Ref: 2025/90517

Consultation Response – Outline application, including the consideration of access and layout, for two commercial units (use class B2 and/or B8) and associated works. Land off Forge Lane, Thornhill Lees, Dewsbury, WF12

West Yorkshire Ecology Service submits the following comments:

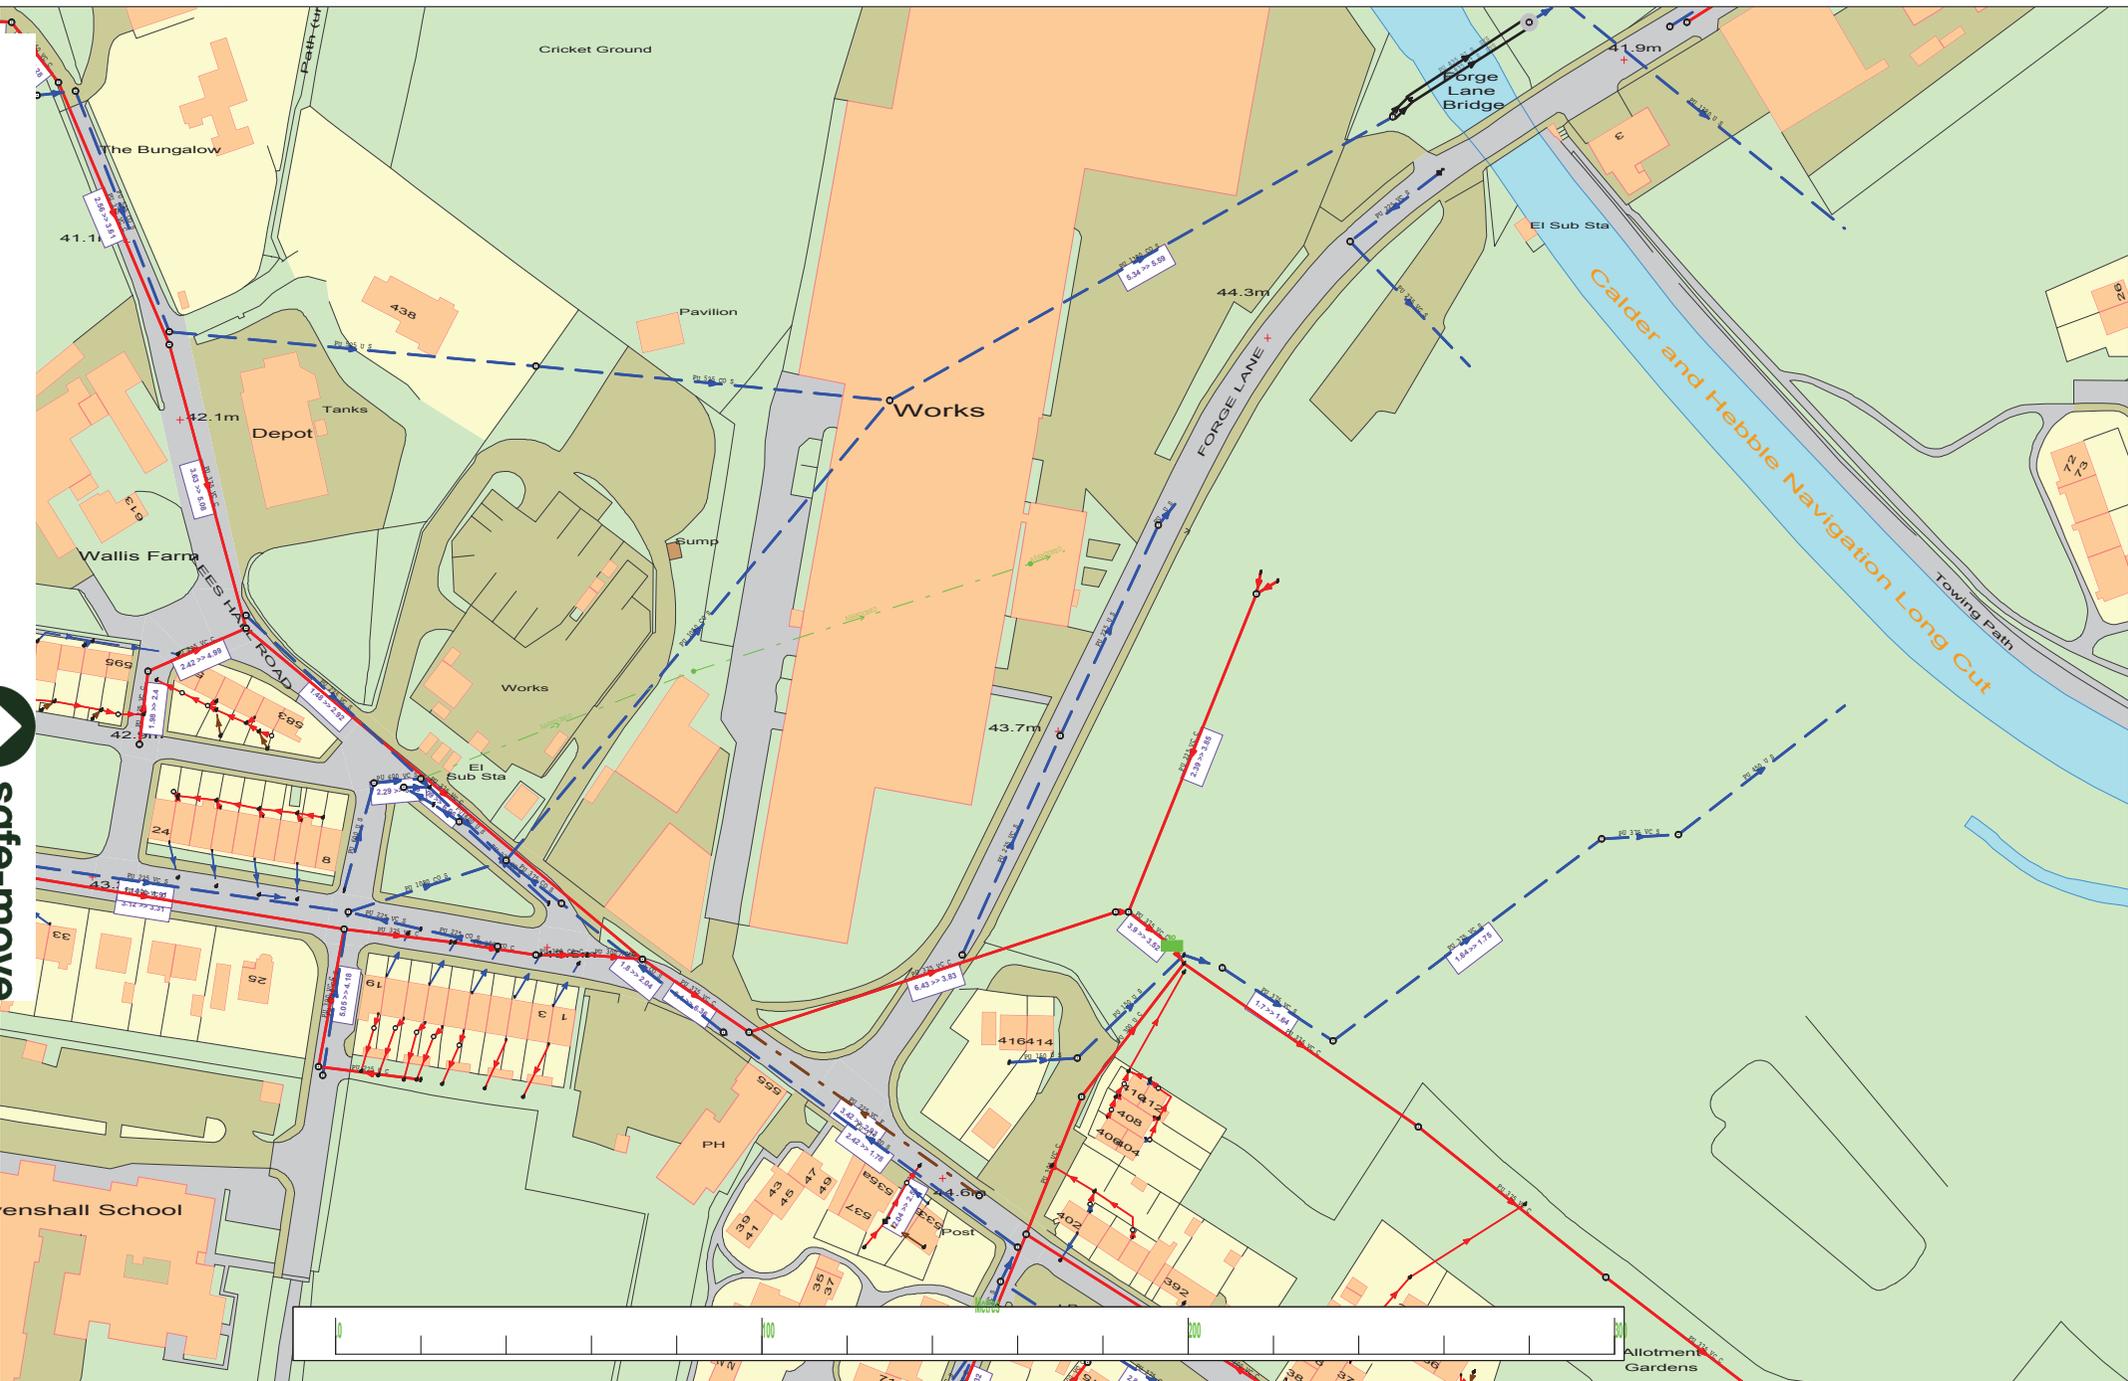
2. The Height and Massing of the buildings have been handled as a reserved matter in the application. These together with the impact of off-site tree planting along the canal are essential in looking at the shading impact on plants within the canal. The application demonstrates that it may be possible to develop part of the site with mitigation but has not currently adequately addressed limitations which should be imposed to protect the plants in the canal, as described in point (1).

3. We would also highlight the potential for lighting impacts along the canal corridor, in particular with respect to the potential for impacts on bats and otters. Details of light spill mitigation from the site onto the canal corridor are necessary to assess the potential for such impacts.
